Town & Country Planning Act 1990 (as amended)
Town & Country Planning (Development Management Procedure) (England) Order 2015
Application for Planning Permission for Works or Extension to a Dwelling

Development Single storey rear extension, first floor side extension.

Location 392 Chichester Road Bersted

PROPOSED FIRST FLOOR PLAN

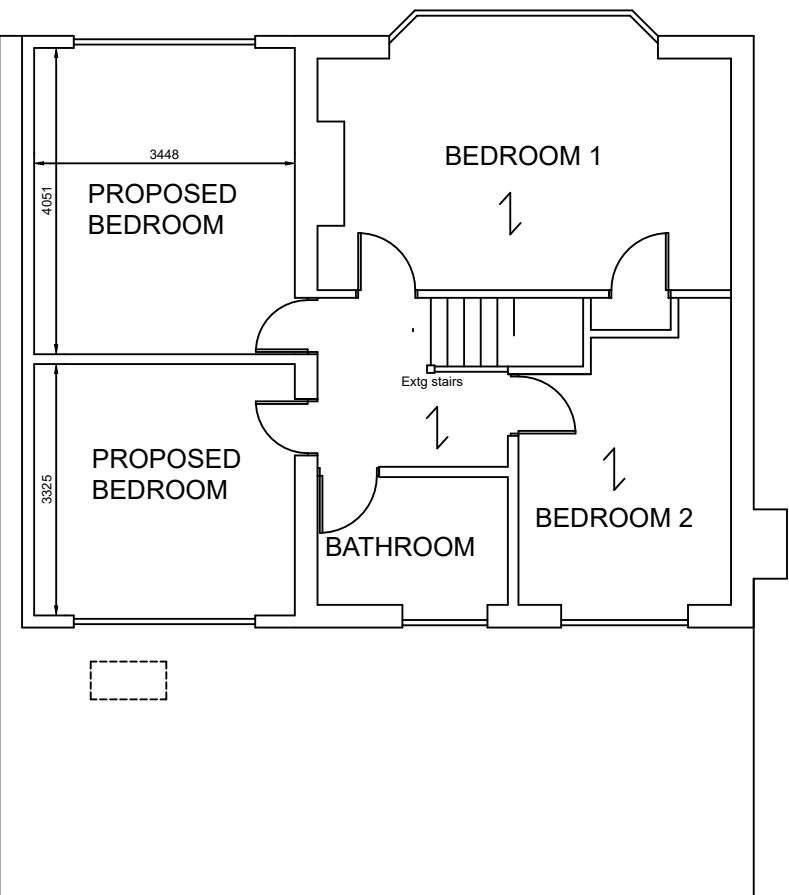
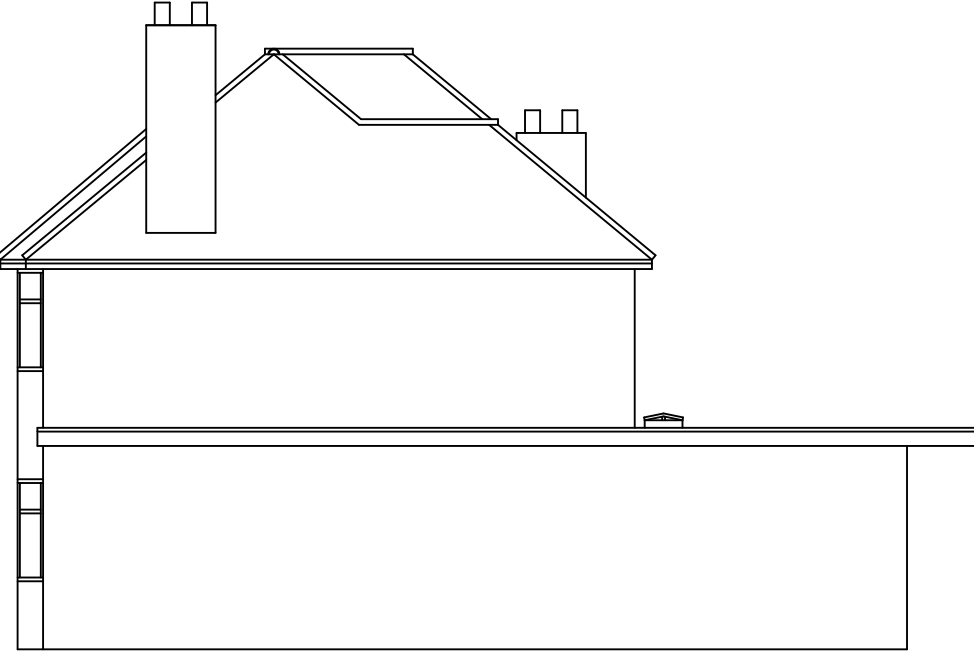
Building Lines: The building lines are inconsistent between the first floor plan and proposed front and rear elevation.
